Response to Submissions

Building R5
One Sydney Harbour

Submitted to Department of Planning and
Environment
On behalf of Lendlease (Millers Point) Pty Ltd

13 May 2019 | 2190302

Response to Submissions (RtS) Landscape Design Drawings

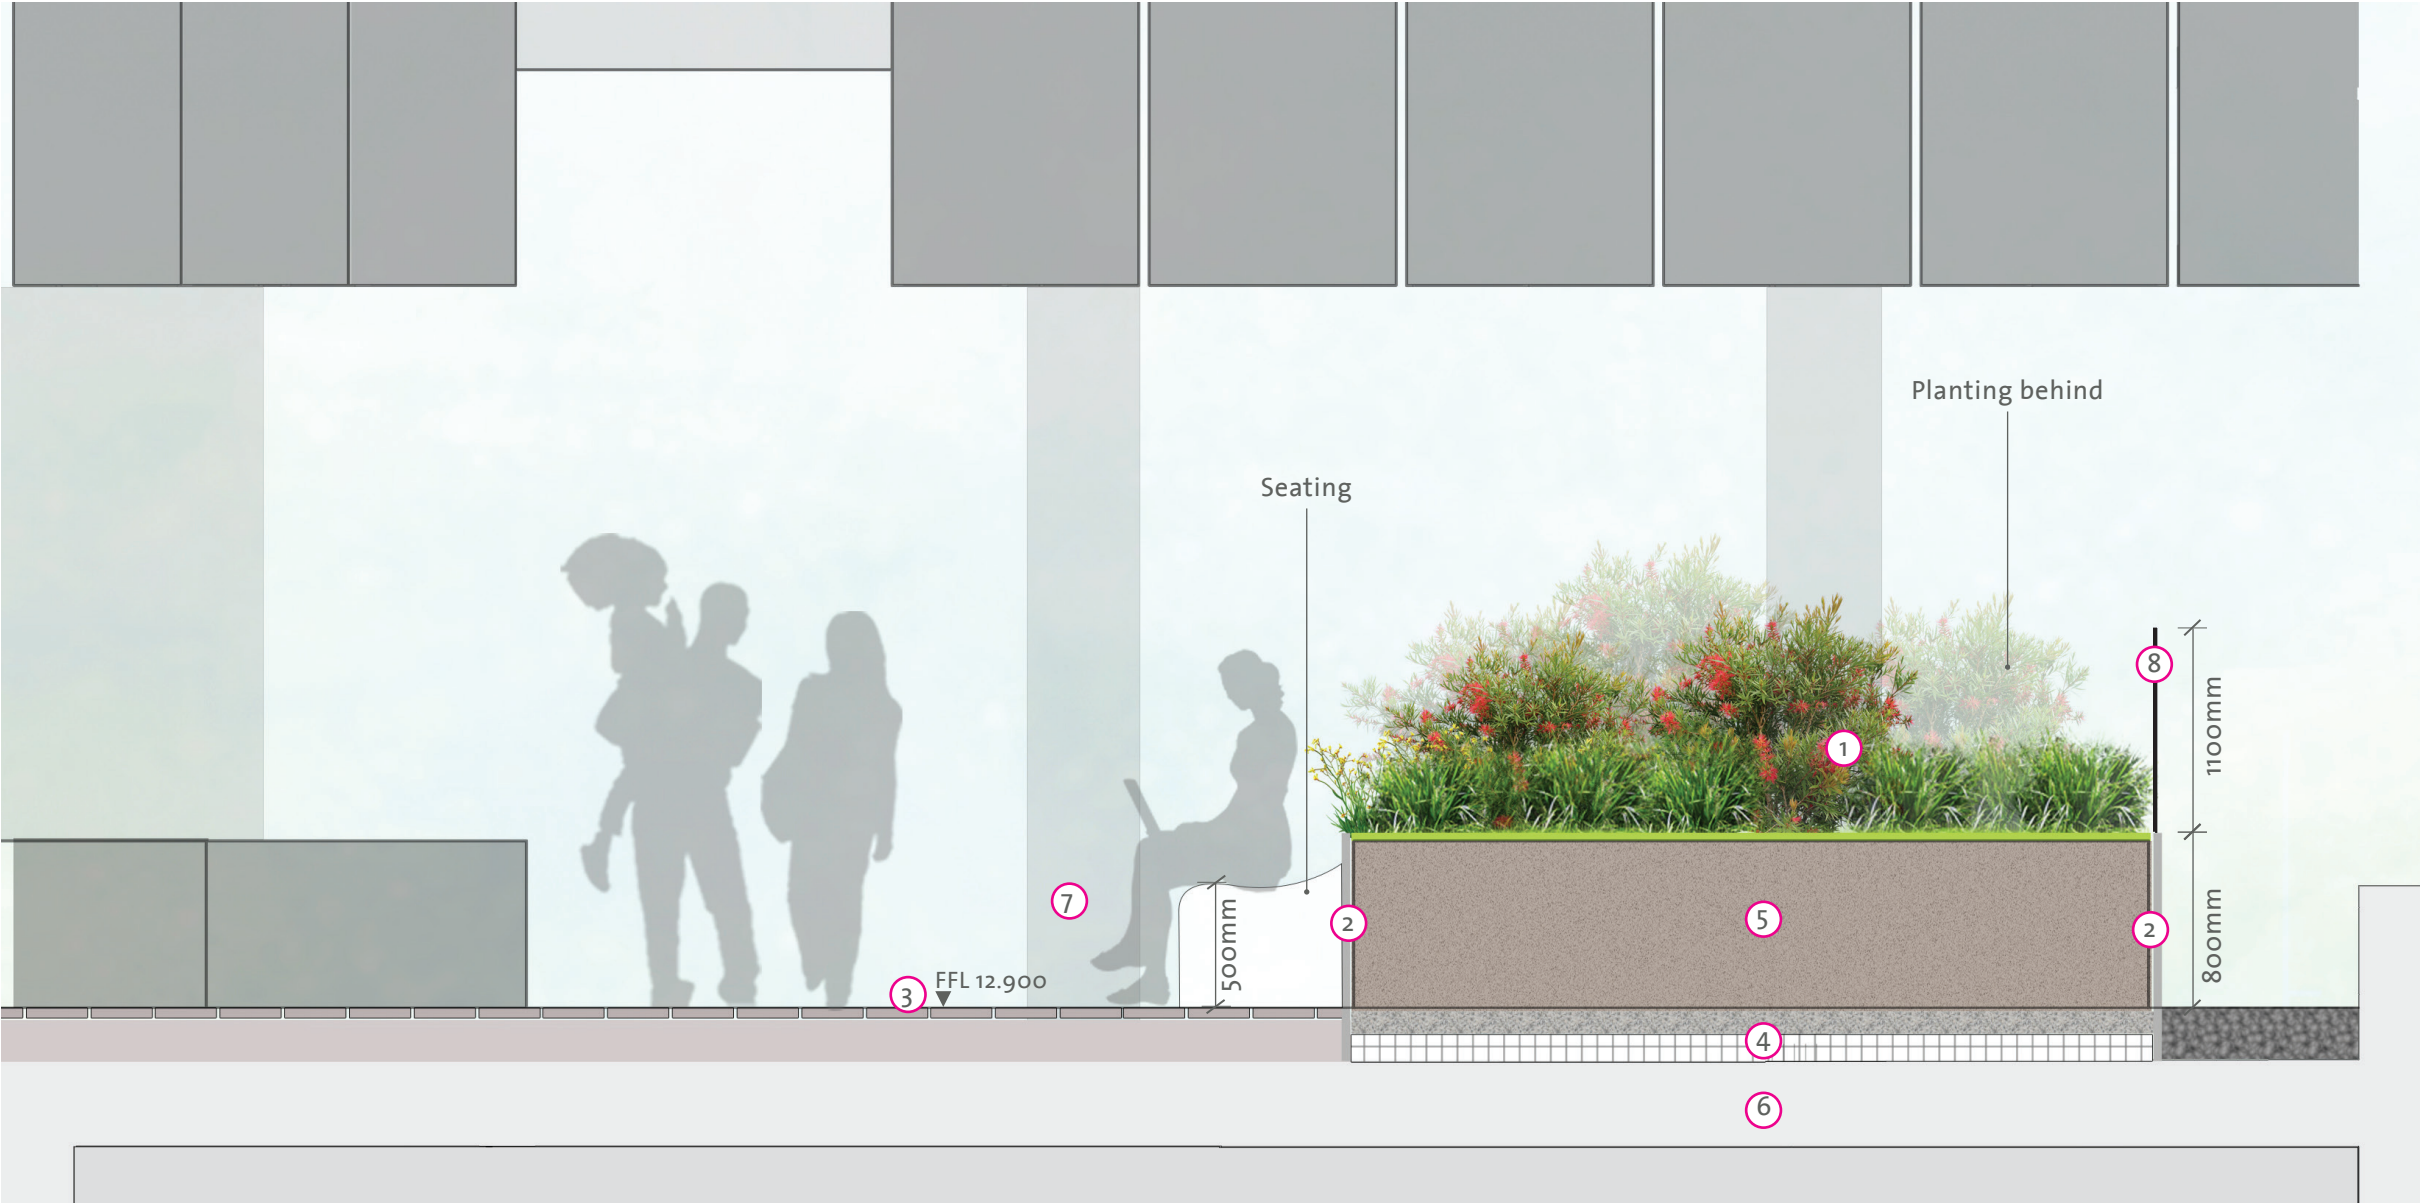
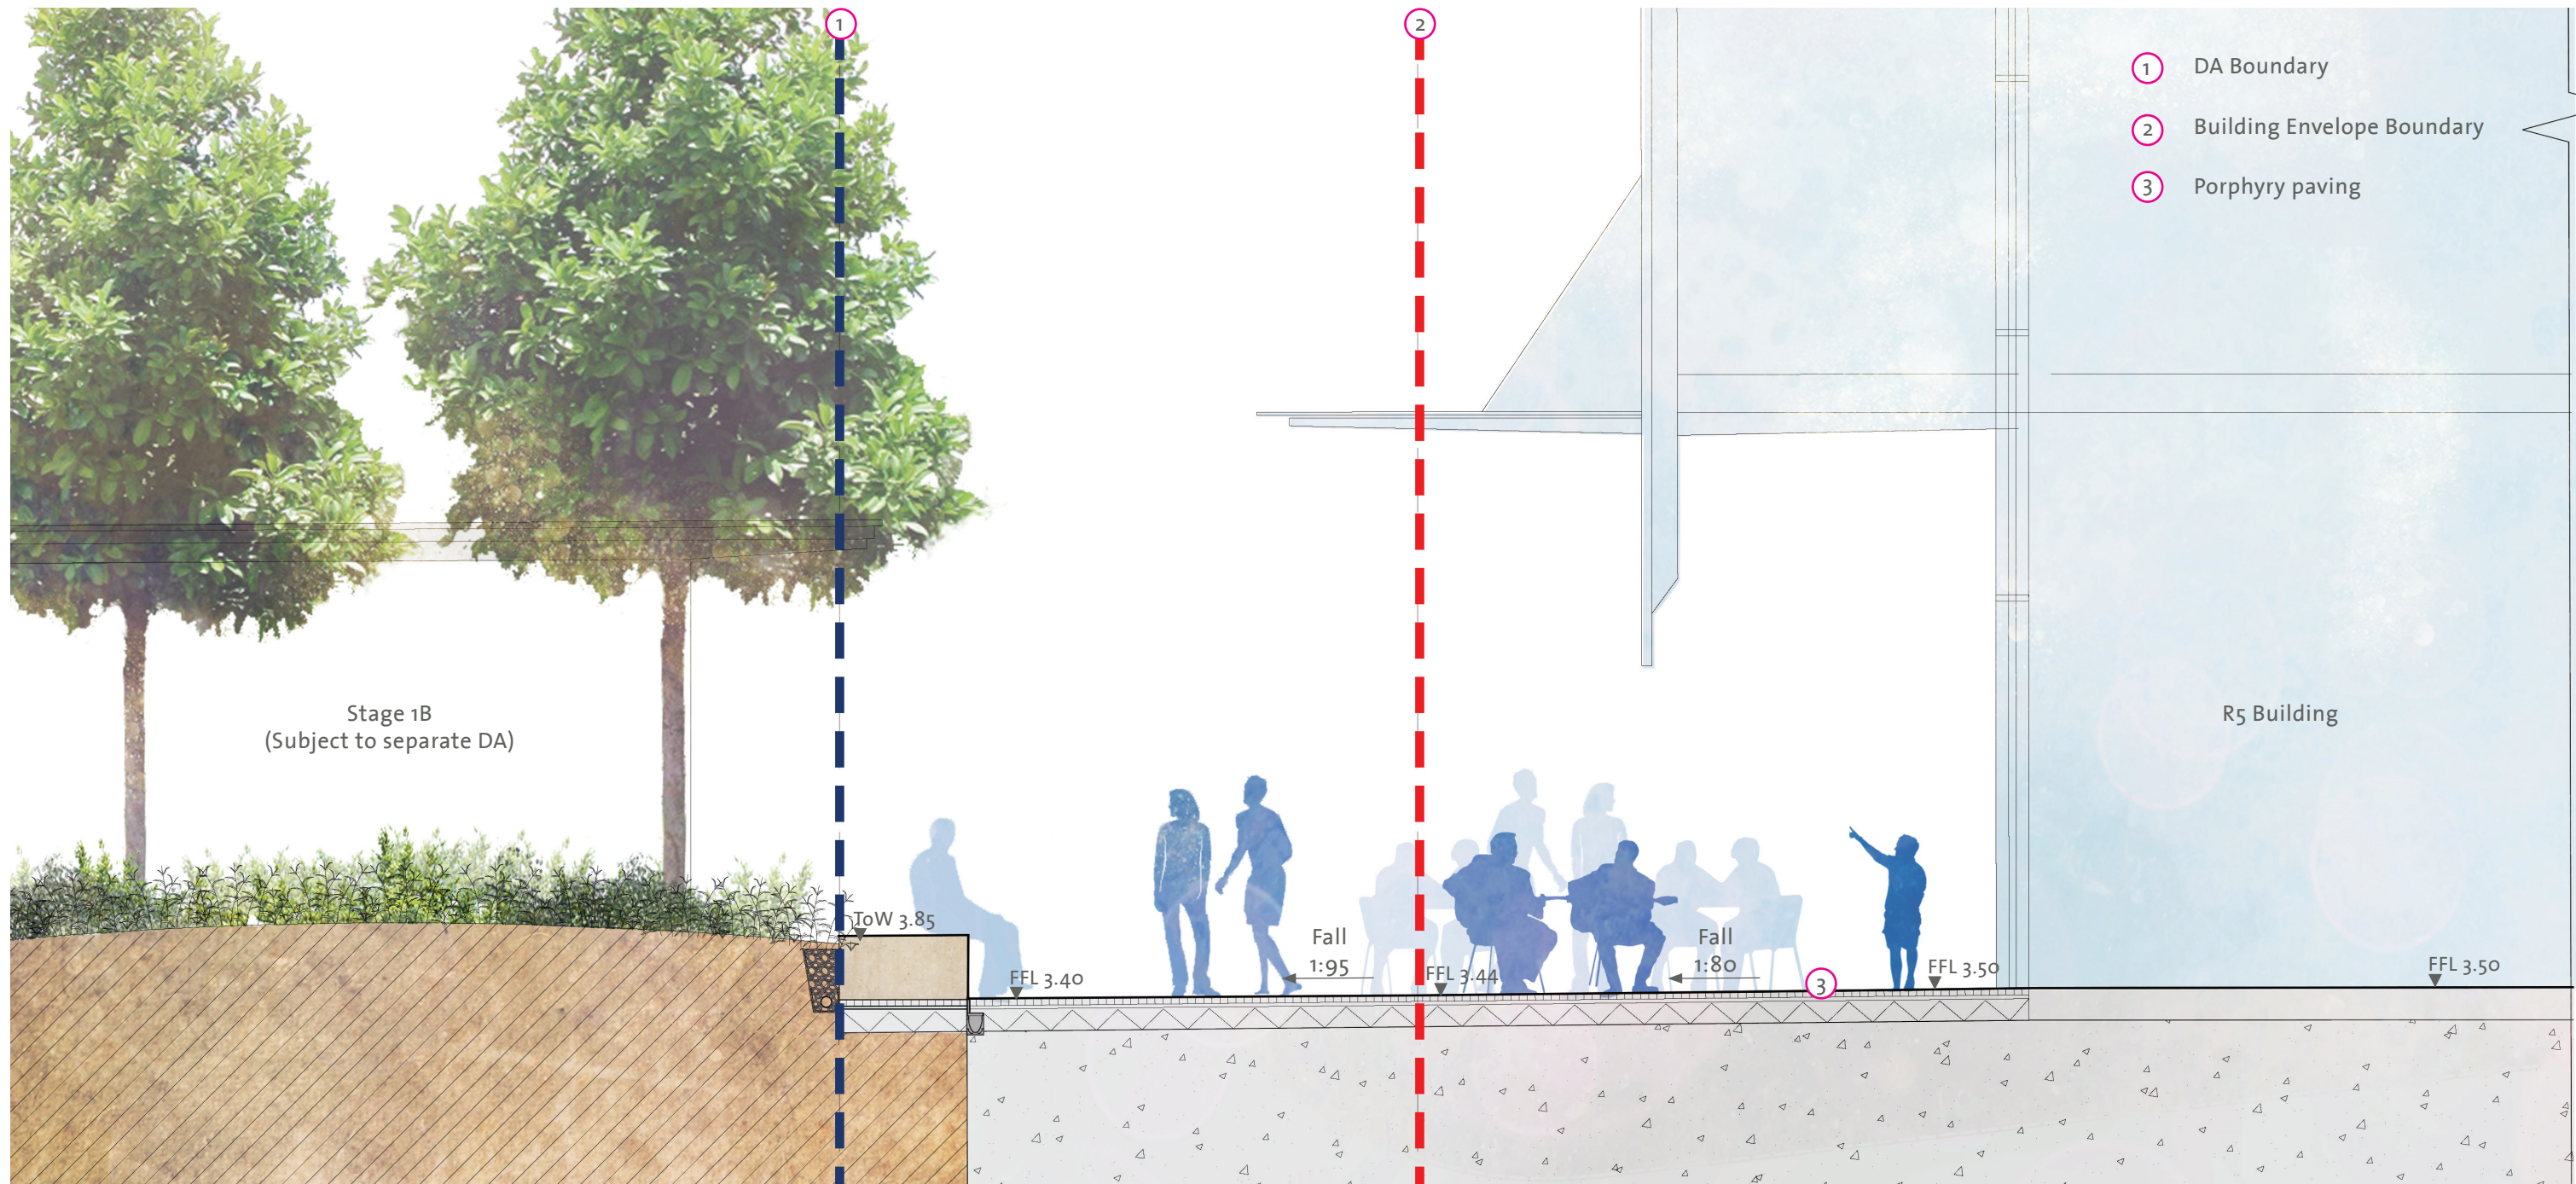
<p>23.0 Ground Floor Plaza Tree Planting</p> <p>No design detail has been submitted for the 4 trees proposed at ground level within the plaza (and within the building envelope boundary) – see below.</p>	<p>Updated landscape plans are provided at Appendix J and detail the proposed tree planting. This is addressed at 6.1 above.</p>

Comments Received	Response
<p>23.1 Ground Floor Plaza Tree Planting</p> <p>There is insufficient information for the design of common open spaces. The plans are conceptual with no levels, minimal annotations, no planting design or schedules. This is not acceptable for a detailed (and final) development application.</p> <p>For example, the Section drawing (dwg RPB430-SE-R5004[G]) indicates 800mm depth raised planter with trees and shrub species is proposed, which is insufficient. A minimum 1000mm soil depth is required for tree planting on slab. In addition, there is no balustrade shown on top of the parapet at the edge of the perimeter maintenance path. The design is not compliant with BCA and Working at Height regulations.</p> <p>The landscape design requires amendment to provide adequate soil depth for tree planting on slab and the inclusion of safety balustrades. Details on the design of raised planters and free standing pots, soil depth and volume for trees on slab, plant schedule are missing.</p>	<p>Updated landscape plans are provided at Appendix J and detail the design of common open spaces. These detailed plans confirm that the proposed design is compliant with the BCA and that appropriate soil depth can be achieved for the proposed planting.</p>

<p>23.2 Common Open Space Generally - Level 2 and Level 26</p> <p>There is insufficient information for the common open space. The plans submitted are conceptual in nature with no levels and minimal annotations. The design of covered shelters, trellis with climbers, details on whether furniture is fixed, depth of planters and free standing pots, soil depth and volume for trees on slab, location of balustrades and /or safety anchor points have not been provided.</p>	<p>Updated landscape plans are provided at Appendix J and detail the design of common open spaces.</p>
